**Consultation Response from KC,
 Trees**
2021/93399 Land Adjacent to, 569 , New Hey Road, Mount, Huddersfield, HD3 3XN
Outline application for demolition of agricultural and storage buildings and erection of residential development (& dwellings)
Date Responded: 14/10/21
Responding Officer: NG
Responding Ref: TPO 13/21

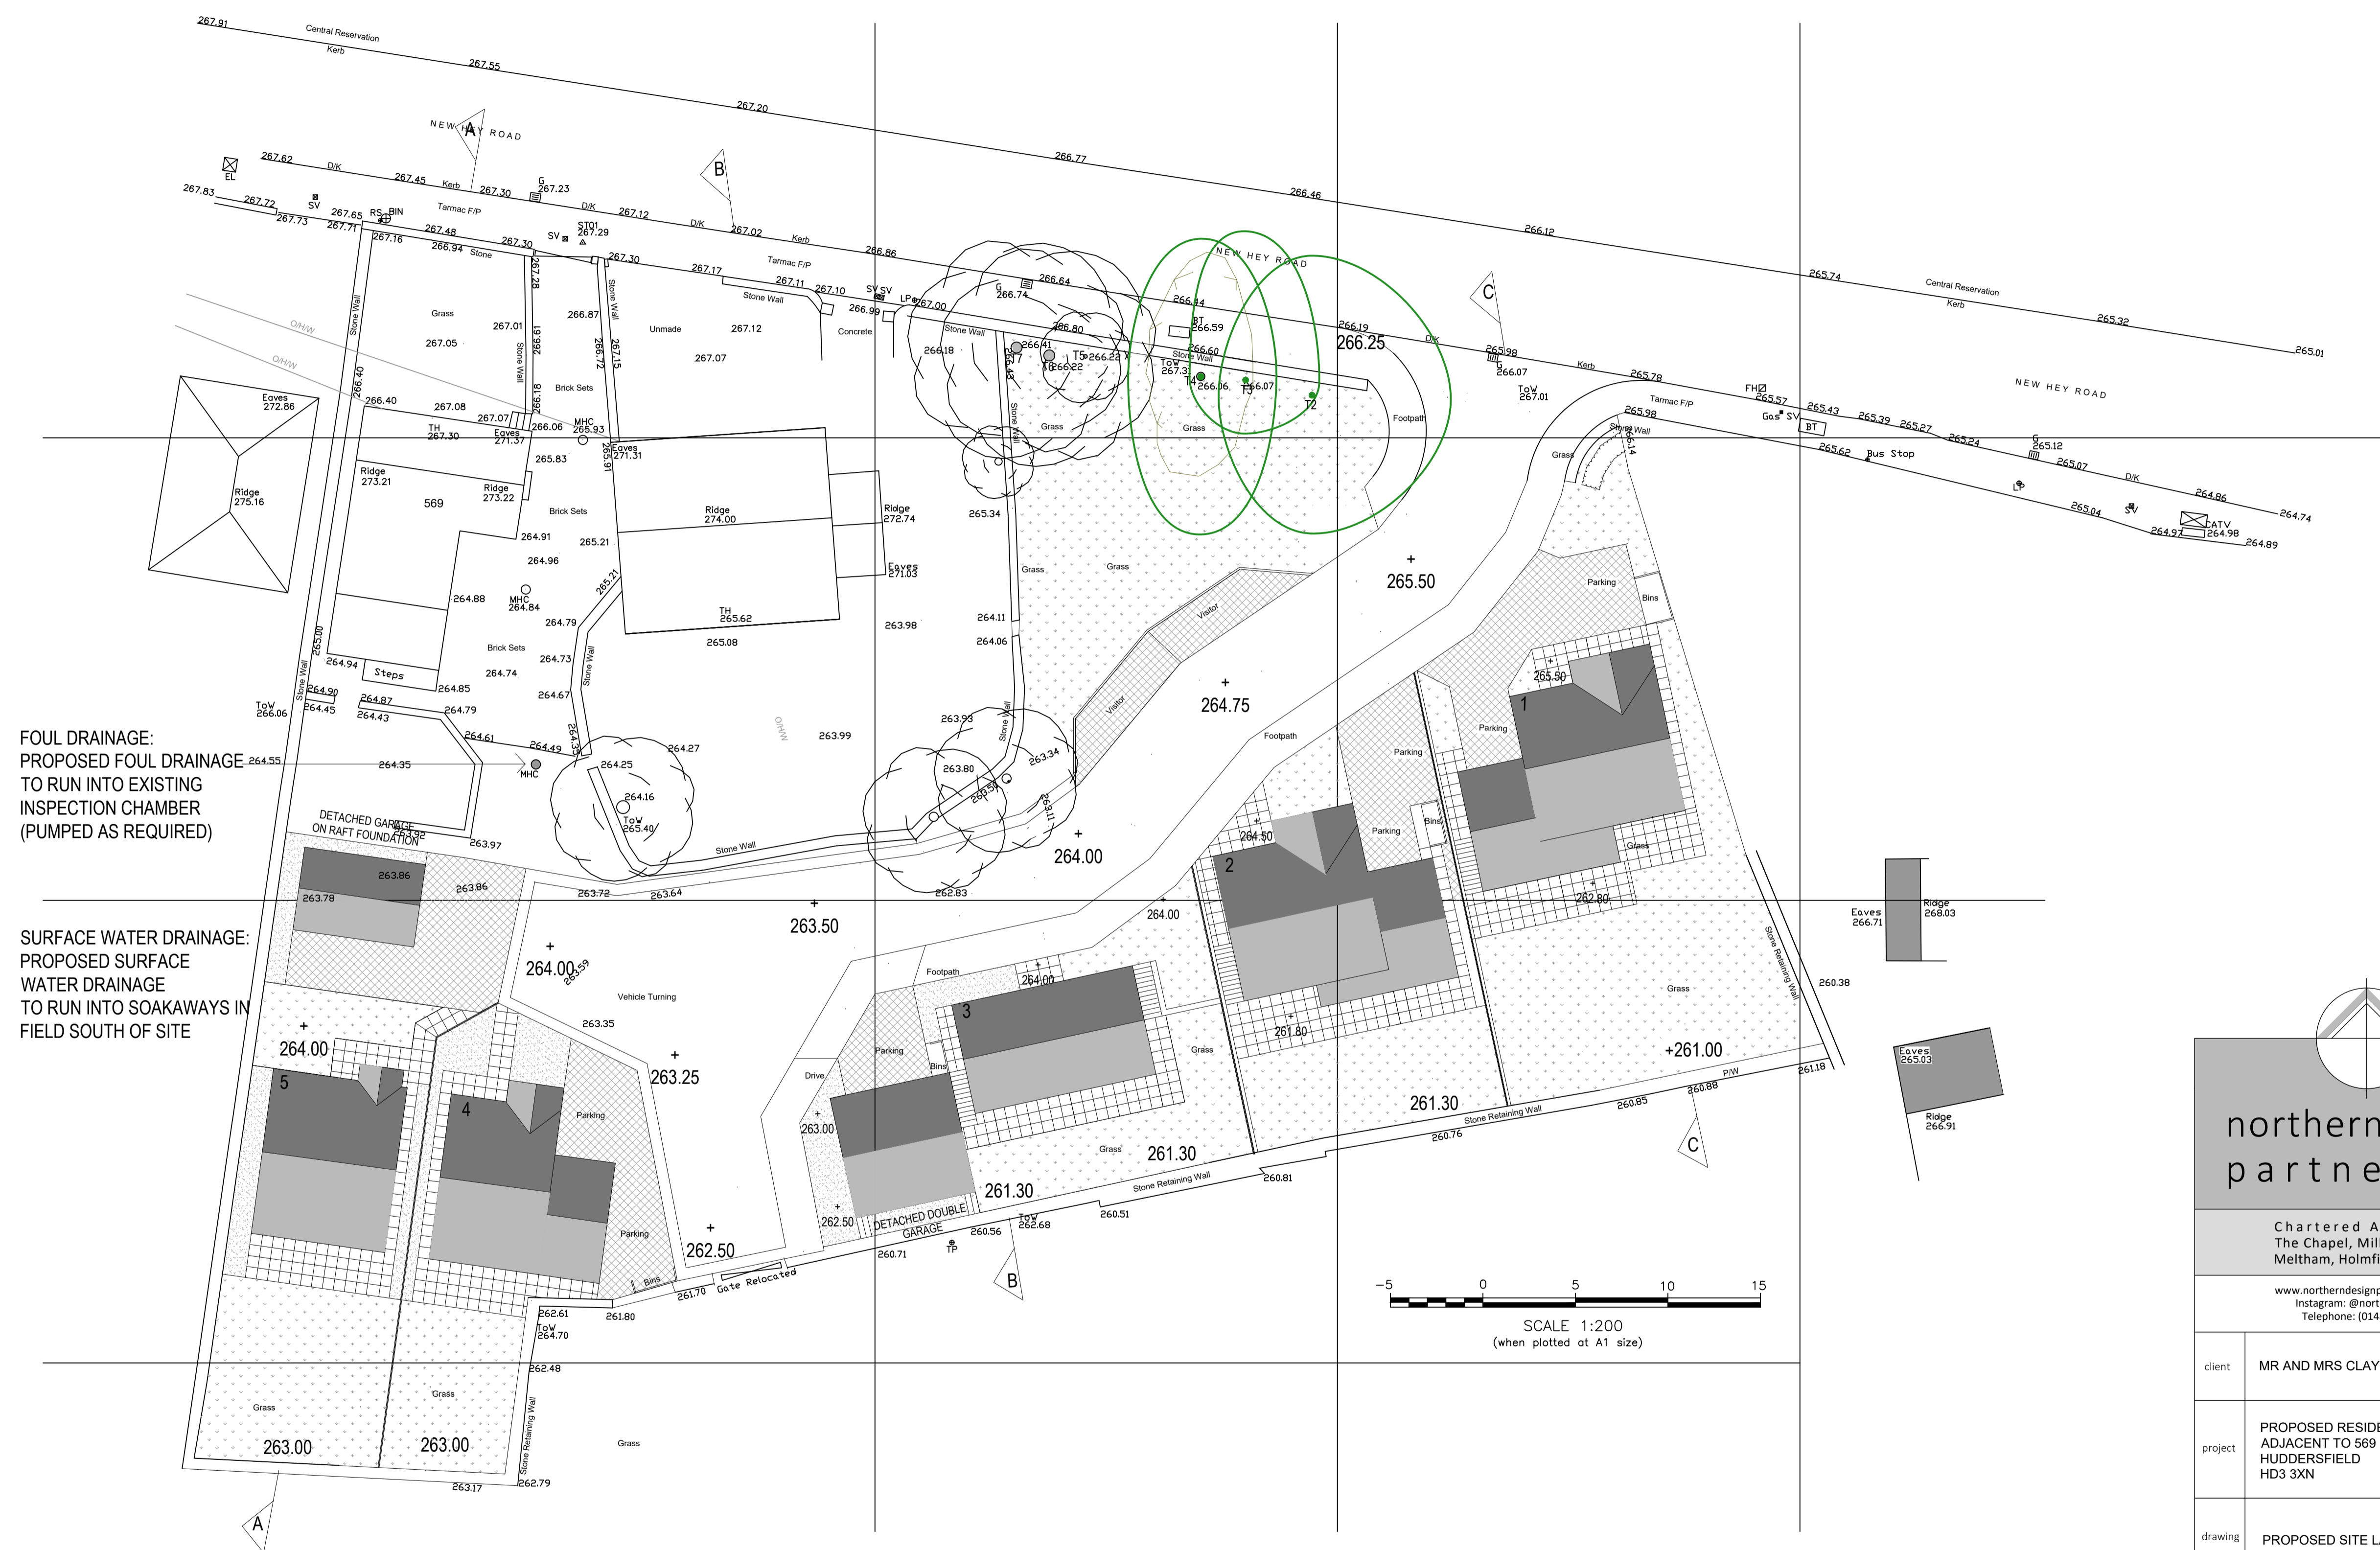
The entrance to the site is where the main impact on tree cover would be noticed. The loss of tree T2, T3 and T4 are of concern and do form part of the new TPO. These trees are located in an area of grass adjacent to the existing access. It appears they need to be removed to widen and move the access further towards no.593 New Hey Rd. The removal of T1, it should be noted is not of concern due to its poor form.

I would hope that the designs could be tweaked to allow the retention of at least T4 and mitigation planting be incorporated on the road frontage between T4 and T5 and near T1. This may be possible by adjusting the location of the first dwelling and would better preserve and ensure the line of trees along New Hey Road.
